Application number: 2023/90349	
What is the application for?:	Erection of detached dwelling
Address of the site or building:	adj, 11, Park View, Cleckheaton, BD19 3AN
Postcode:	BD19 3AN

Proposed:  
Floor Plans  
Elevations

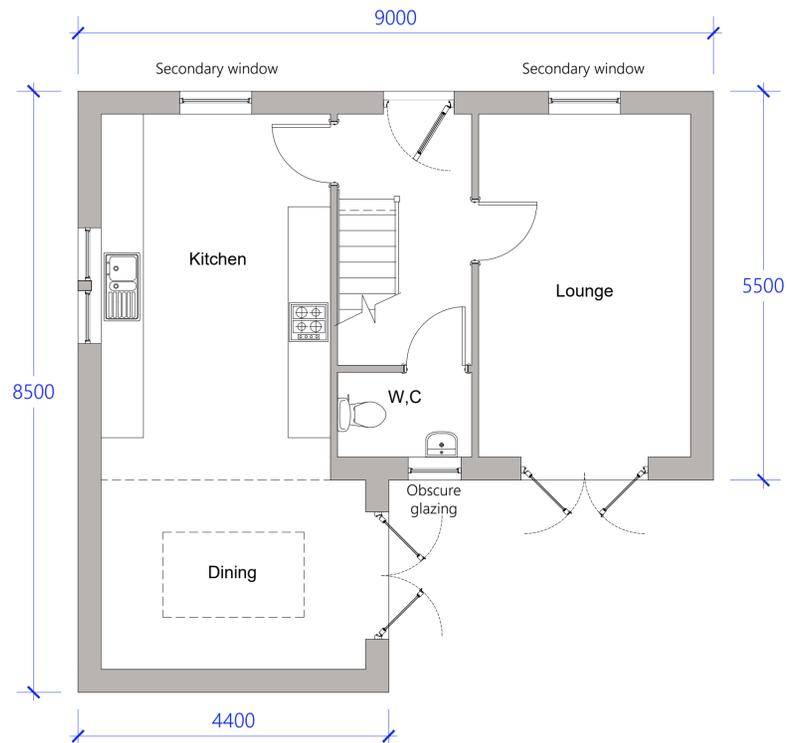
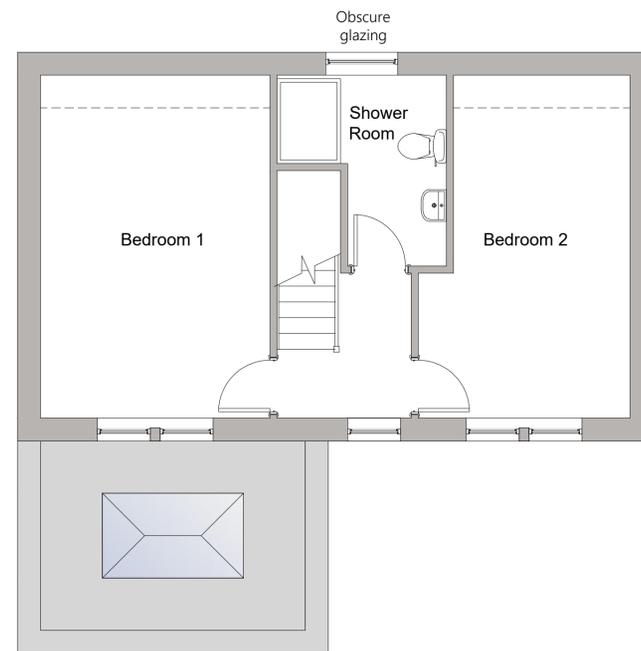
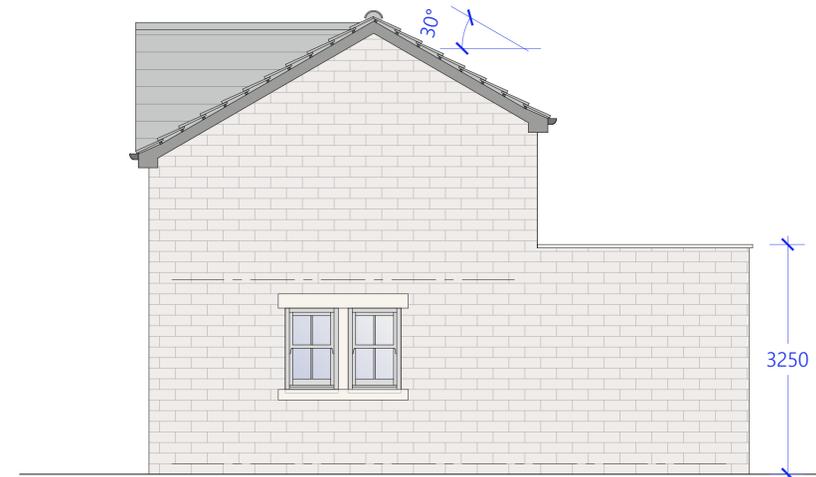
Type of comment: An objection	
Do you wish your comments to be published on the website anonymously?	Yes
<p>The new dwelling will not be in keeping with the surrounding houses. There is already limited parking on the street and this dwelling will make this worse. The windows will overlook several houses. The new dwelling will shade several gardens.</p>
